**St MATTHEWS CATHOLIC COLLEGE, MUDGEES (SSD 9872)
CORNER BROADHEAD ROAD AND BRUCE ROAD, SPRING FLAT (MUDGEES)
RESPONSE TO SUBMISSIONS**

RESPONSE TO DPIE KEY ISSUES AND AGENCY, COUNCIL & PUBLIC SUBMISSIONS

**LEVEE BANK PLAN**  
SCALE 1:500 AT A1

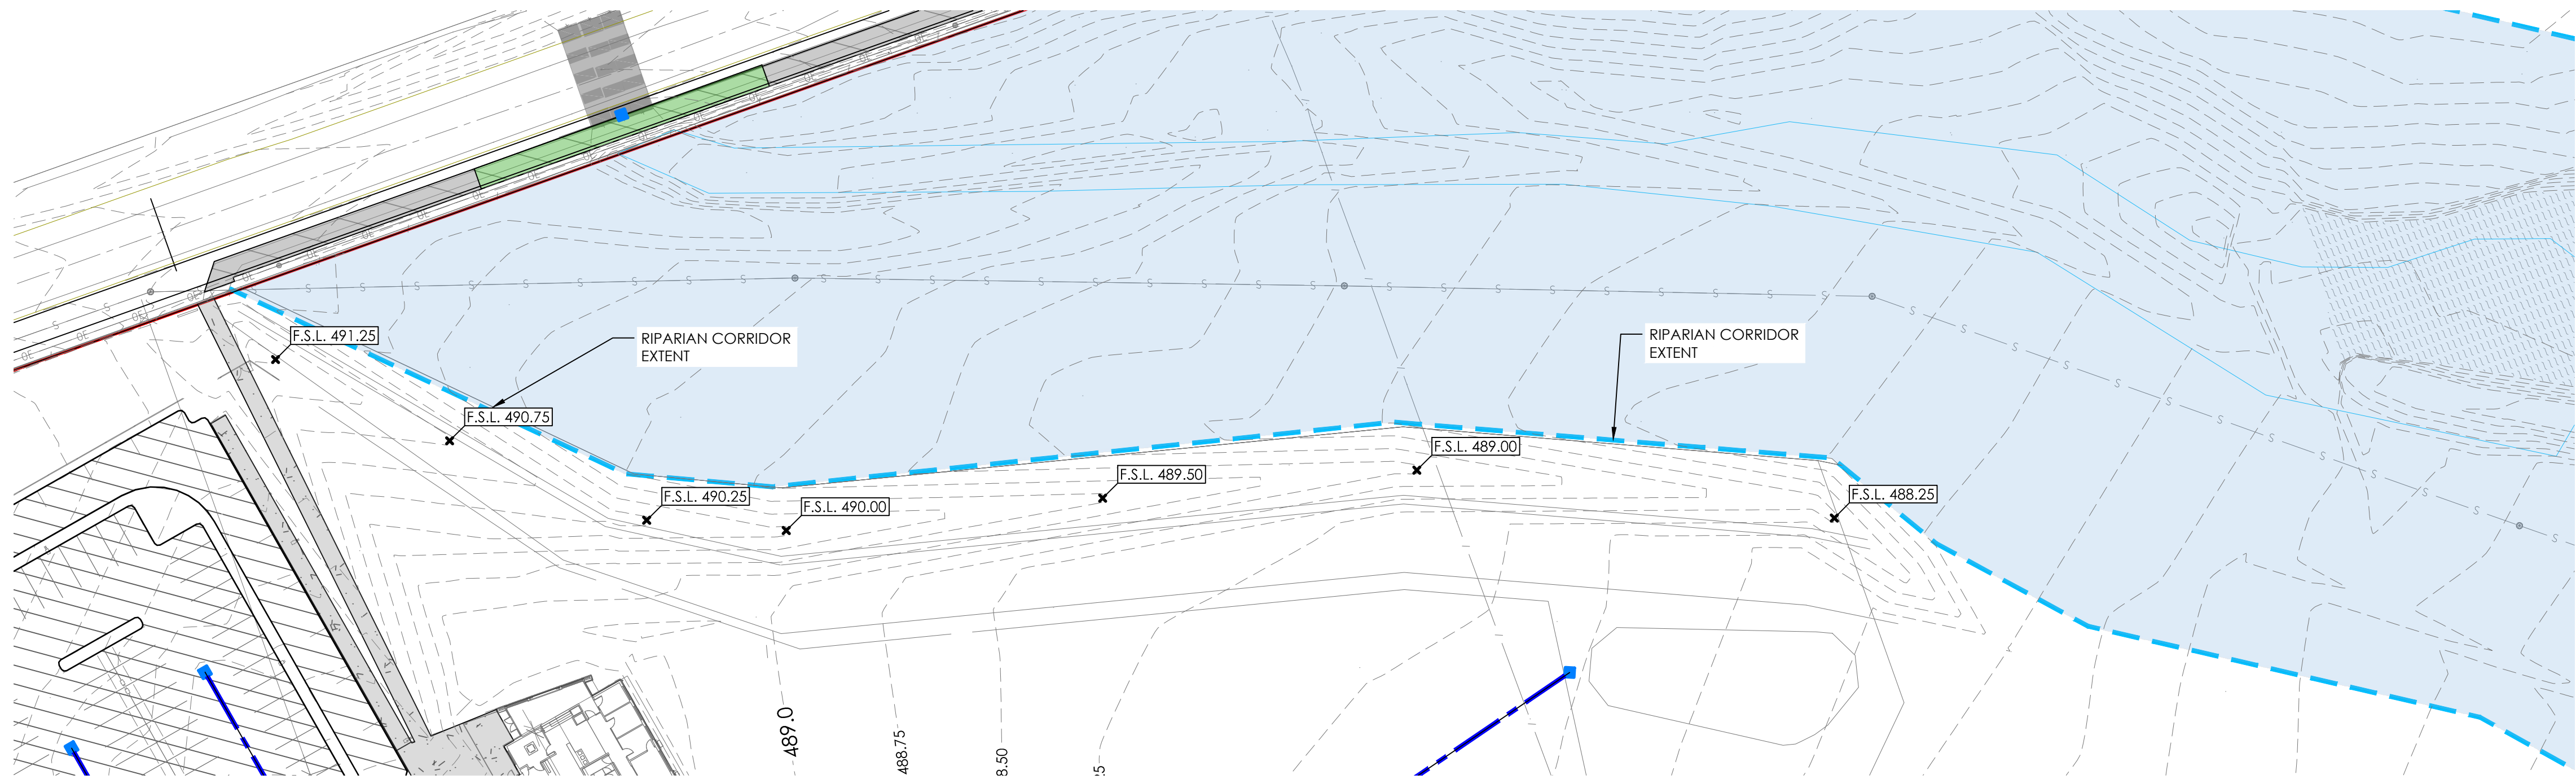
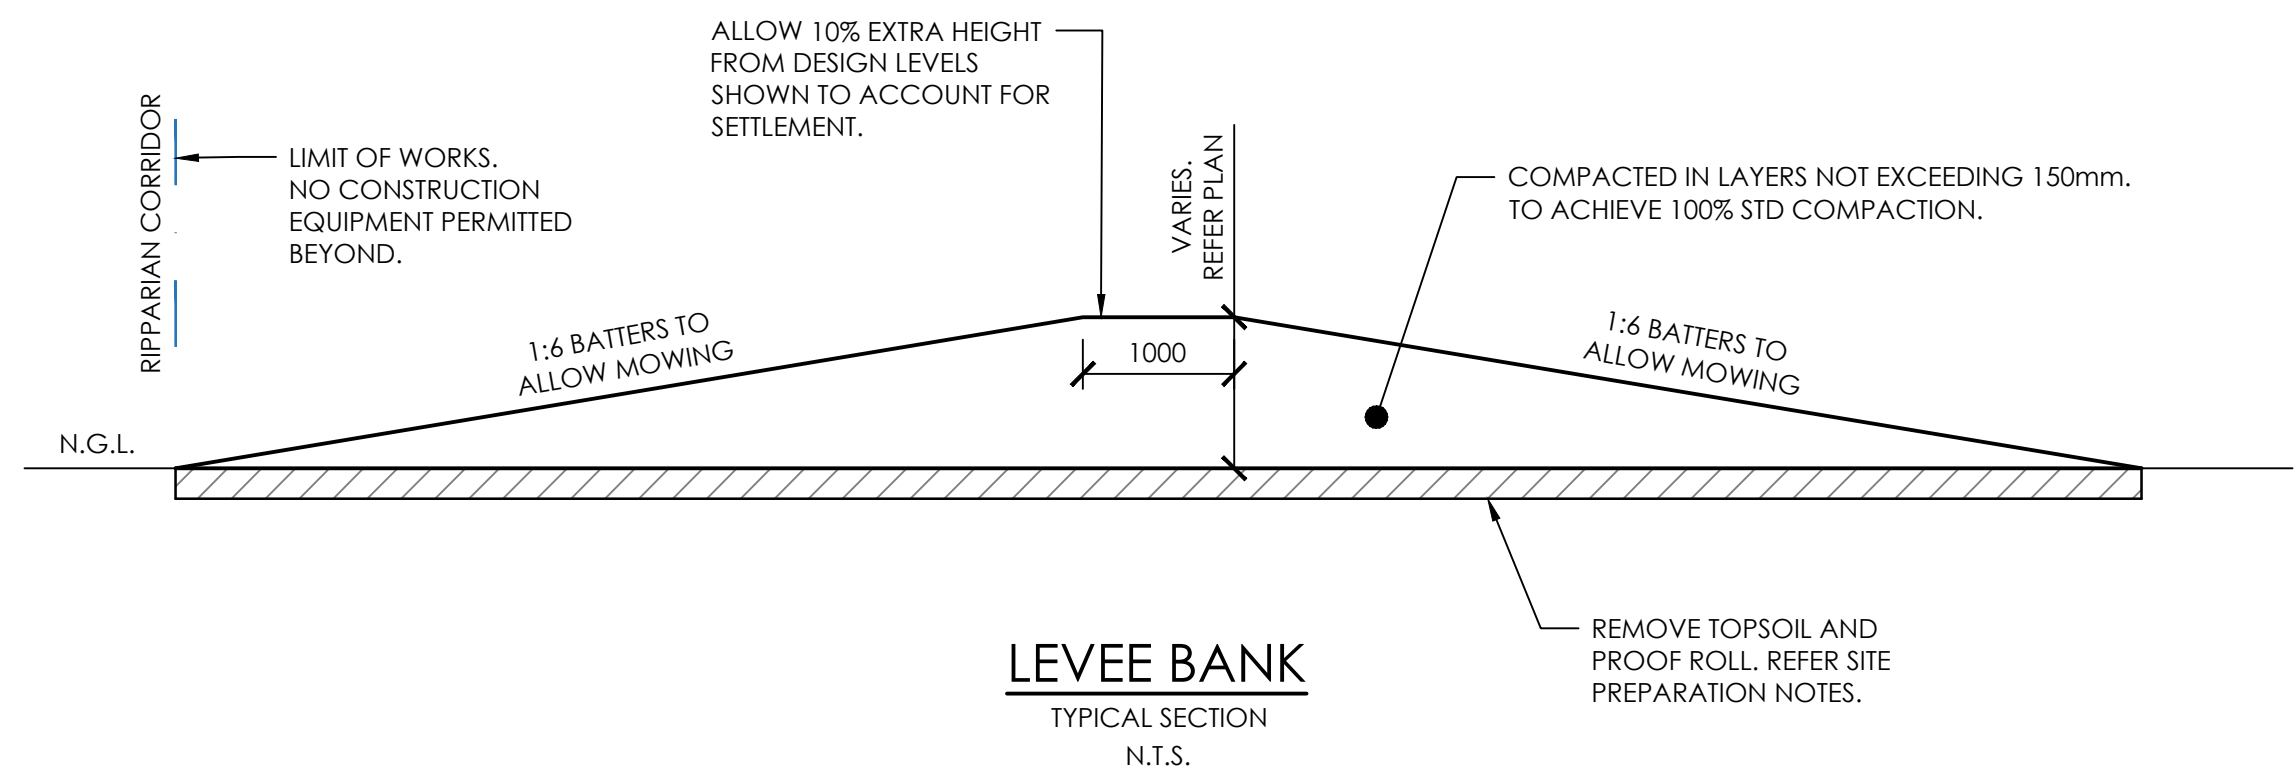
<p>addressed in the updated civil plans (stormwater and roadworks).</p> <p>Based on this low velocity sheeting of waterflow over Bruce Road, the project is required to include a graded and subtle landscaped earth berm (nominally 500mm high) to the Bruce Road frontage of the site to divert upstream water around the buildings. This will be integrated into the landscaping / topography to the extent that its existence will not be noticeable and appear as a continuous landscape feature at that frontage.</p> <p>To safeguard the development and assets, Triaxial has recommended the proposed buildings be raised by 150mm to ensure that there is no water ingress in a 1:100+ year storm event. Note, no building height control applies to the site and no new or material overshadowing arises.</p> <p>The revised Civil Engineering Plans and Architectural Plans addressing this change are included at Appendices G and H.</p>
